Consultation Response from KC, Conservation and Design
2021/91035 66, Blacker Road, Birkby, Huddersfield, HD1 5HS
Alterations to existing dwelling and erection of front and rear dormers to form 4 flats and erection of bike shed (within a Conservation Area)
Date Responded: 19.4.21
Responding Officer: Sue Oakley
Responding Ref:

PROPOSED FRONT ELEVATION

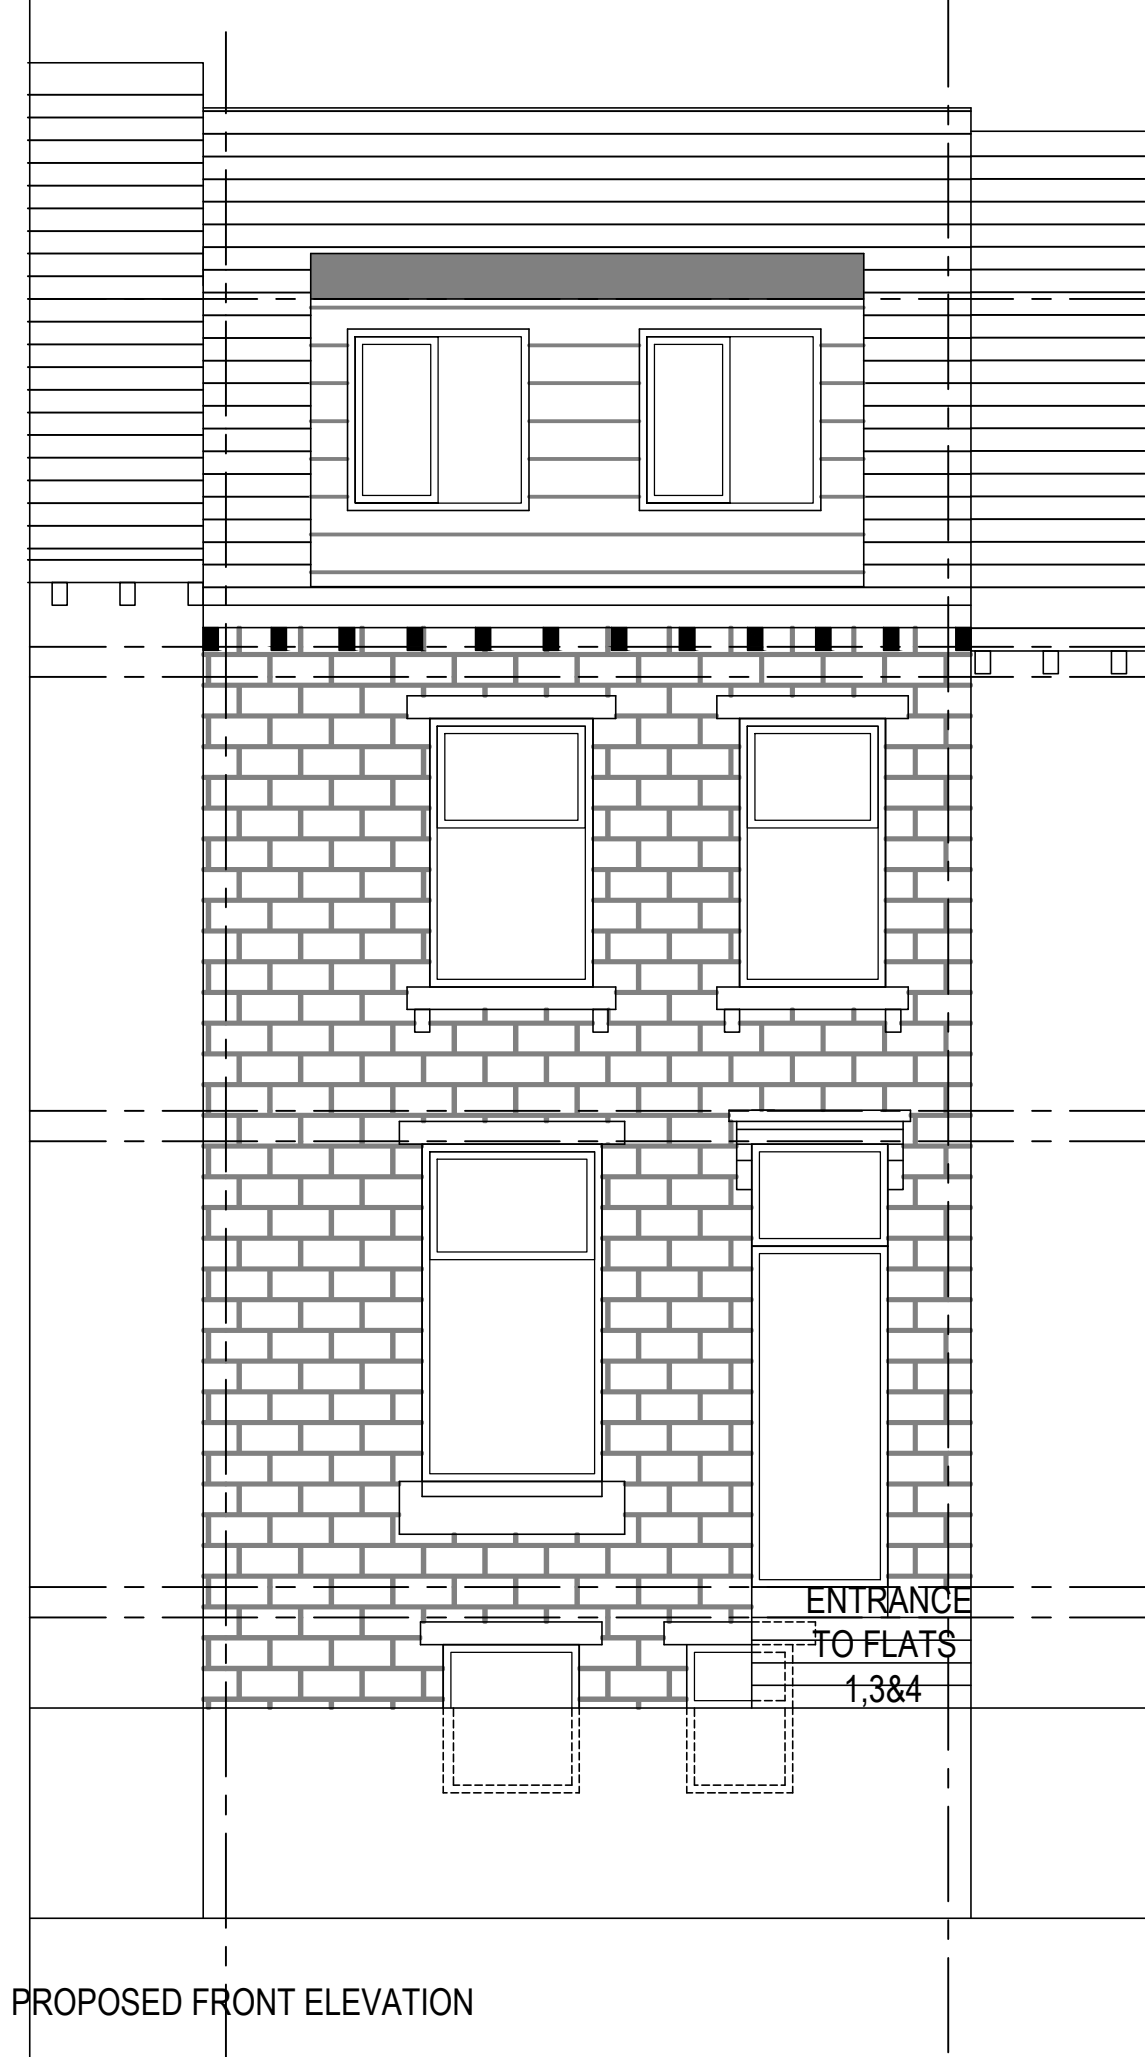
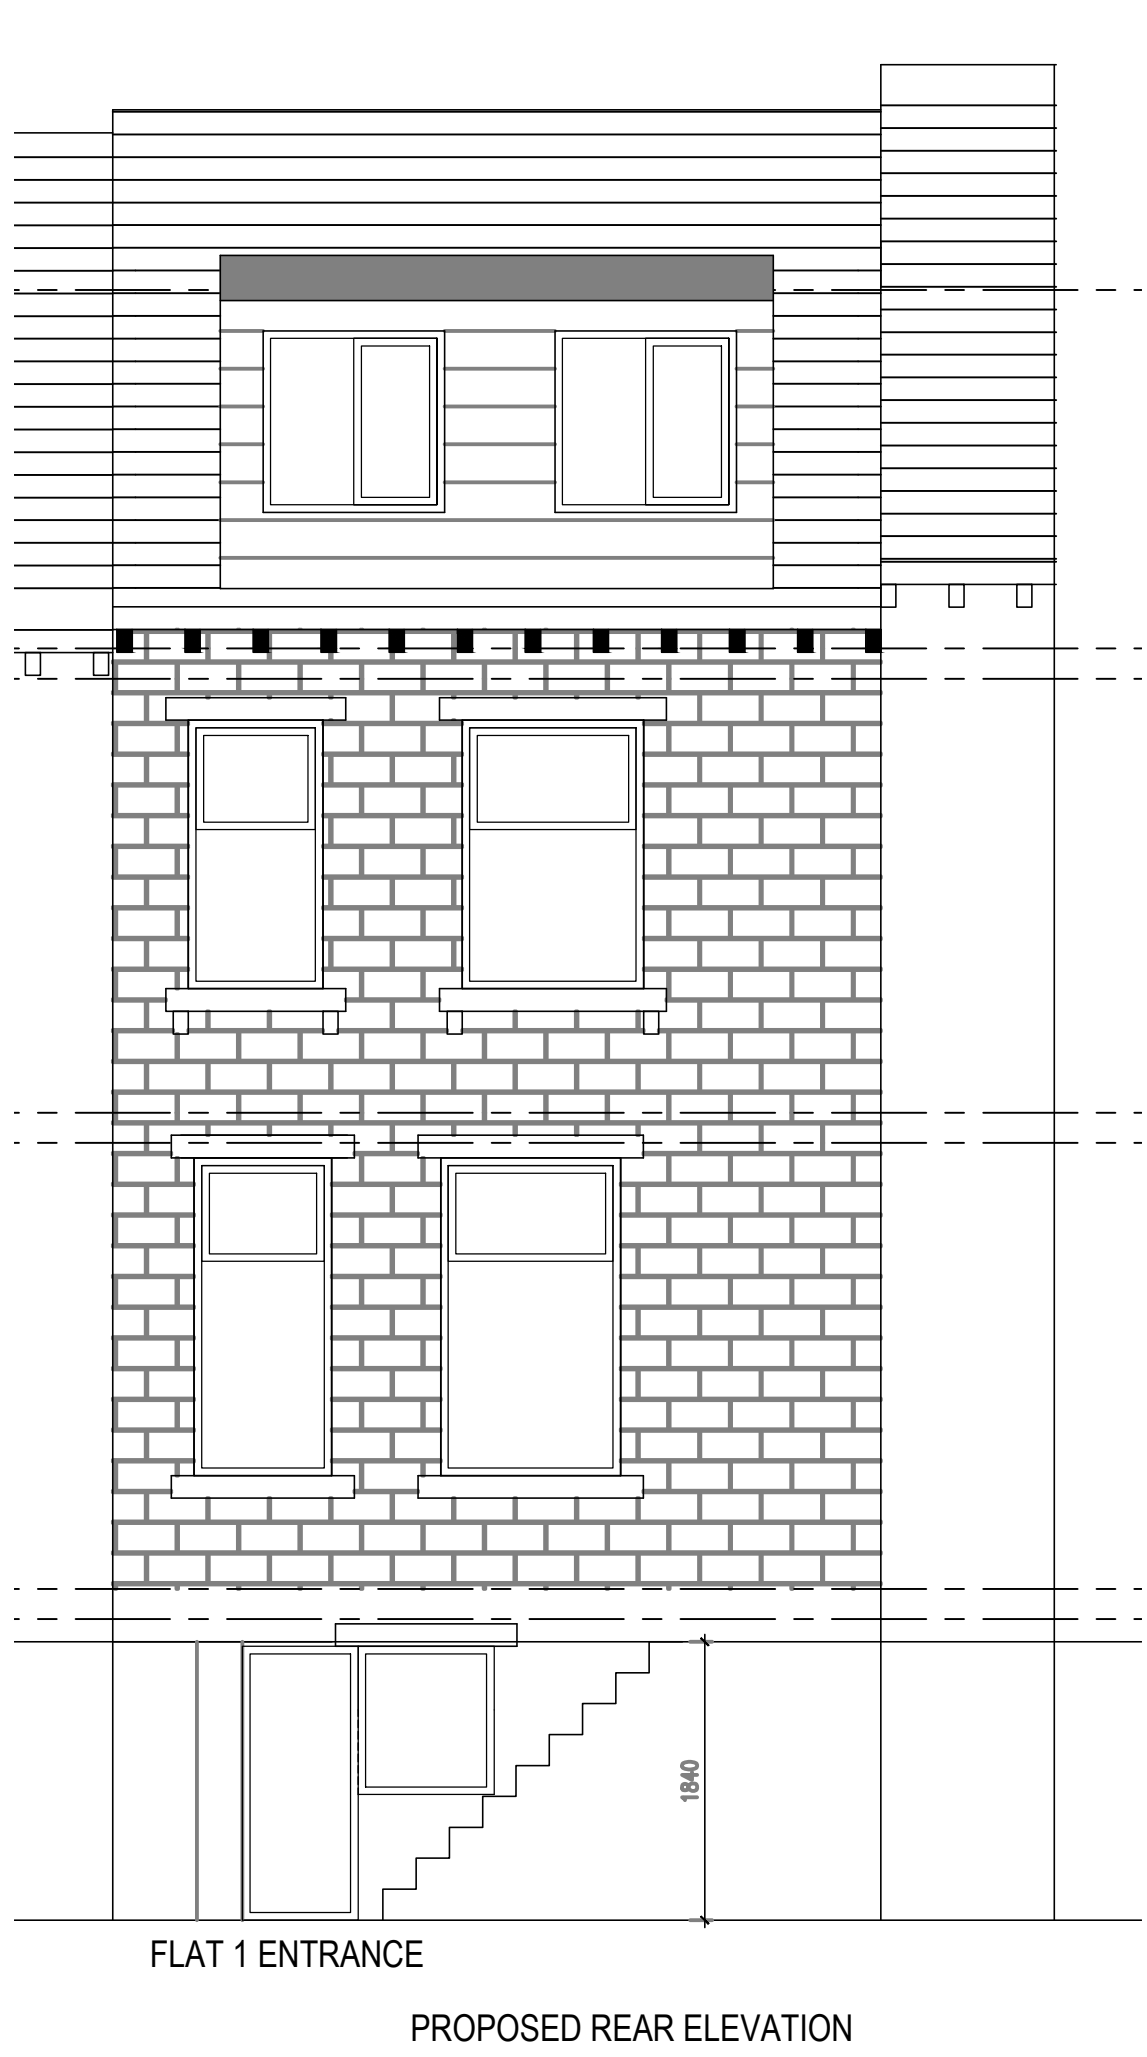
The Design and Access Statement refers to the front dormer at 64 Blacker Road not being in keeping with the visual amenity of the road, but states that the dormers on 66 Blacker Road will not be detrimental to the visual amenity of the street. The Conservation and Design Team would consider that dormers on both properties cause harm to the character of the conservation area.

Inserting a large flat roofed dormer on each roof pitch will lead to less than substantial harm to the significance of the conservation area (the designated heritage asset) by breaking up the simple line of the pitched roofs along this terrace. The harm will be particularly pronounced on the front roof pitch facing Blacker Road, but a full width dormer on the rear pitch will also lead to harm as it is visible from Wheathouse Road and is seen in context with the two listed buildings.

The proposed dormers do not preserve or enhance the significance of the conservation area or maintain the distinctive character of the repetition of the terraces and clean roof lines, which are an important part of the character of this conservation area.

The Conservation and Design Team does not support the proposal for dormer windows.

PROPOSED BASEMENT FLOOR PLAN
(FLAT 1)

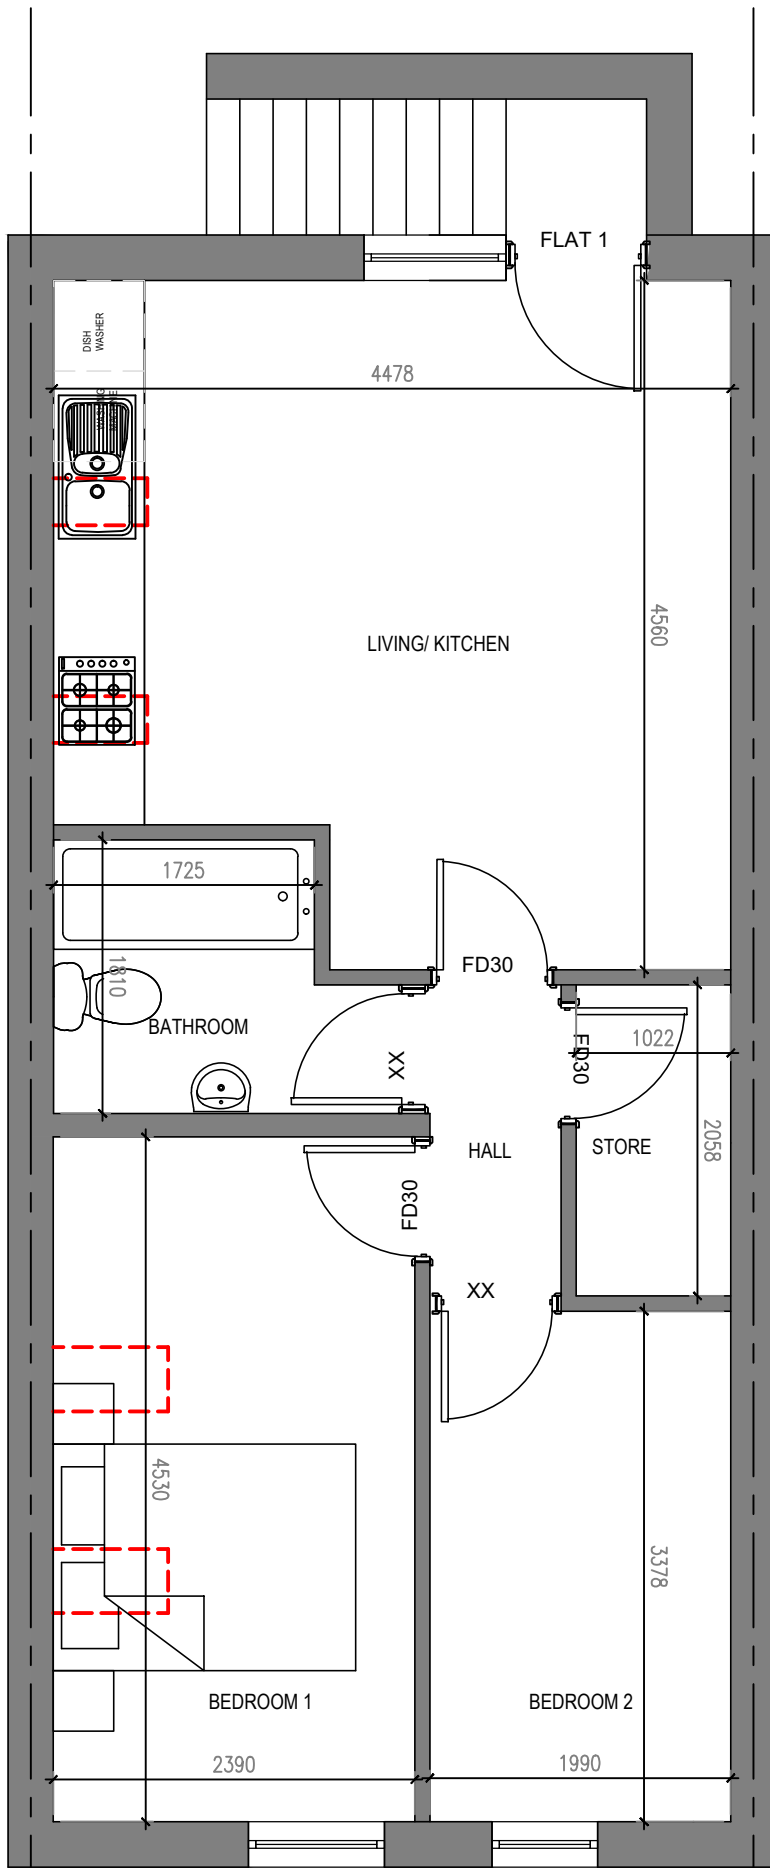
The proposed bike storage shed and rear access to the basement are not of concern, although the drawings do not show the extent of excavation required to create the access.
